Ribble Valley Borough Council
Council Offices
Church Walk,
Clitheroe
Lancashire
BB7 2RA

Phone: 0300 123 6780
Email: Kathryn.Walsh@lancashire.gov.uk
Your ref: 3/2024/1029
Our ref: 3/2024/1029/HDC/KW
Date: 11 March 2025

Location: Bolton Fold Farm Alston Lane Longridge PR3 3BN
Proposal: Proposed construction of two agricultural workers dwellings with access and parking.
Grid Ref: 360137 435333

Lancashire County Council acting as the Local Highway Authority (LHA) does not consider that the application as submitted fully assesses the highway impact of the proposed development and further information is required as set out in this response.

PROPOSED PLAN AND ELEVATIONS

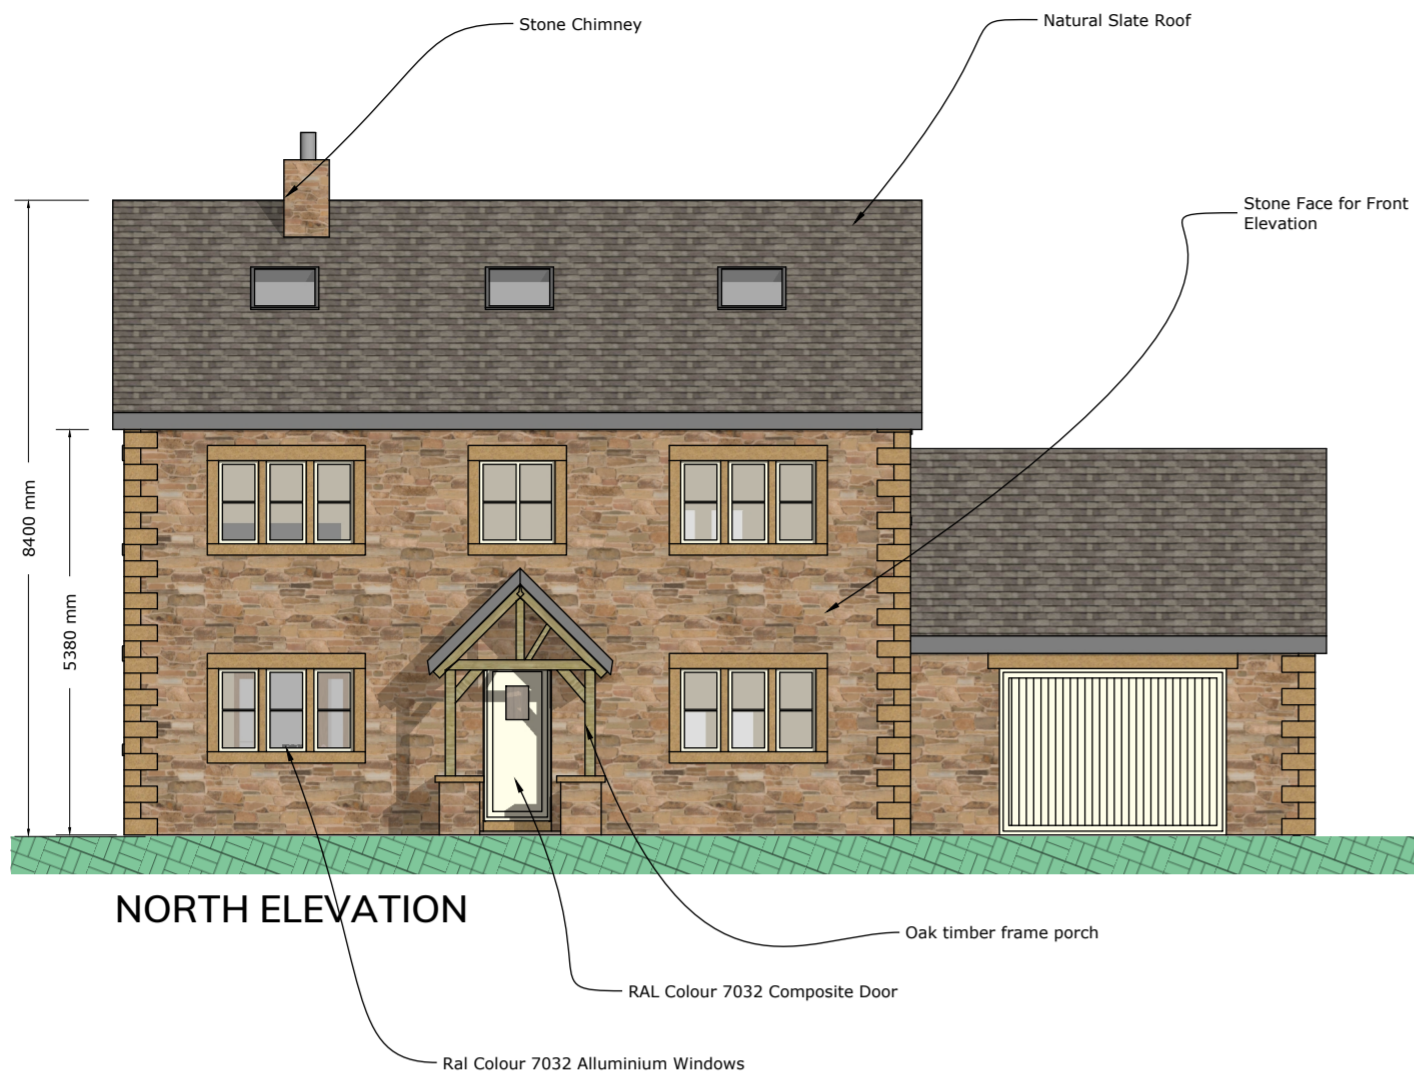
The recommended minimum internal dimensions for a single garage size is 6m in length and 3m wide. The recommended distance of 6m is based on the length of a large family car (Ford Mondeo Estate 4.58m long), clearance at the rear of the car (200mm), overhang of the garage door (600mm) and room to stand in front of the car and open/close the garage door (600mm). The LHA has reviewed the proposed floor plans for both agricultural dwellings, drawing PRO 001 and PRO 002 and note that the garage have been designed to an acceptable internal size to provide parking.
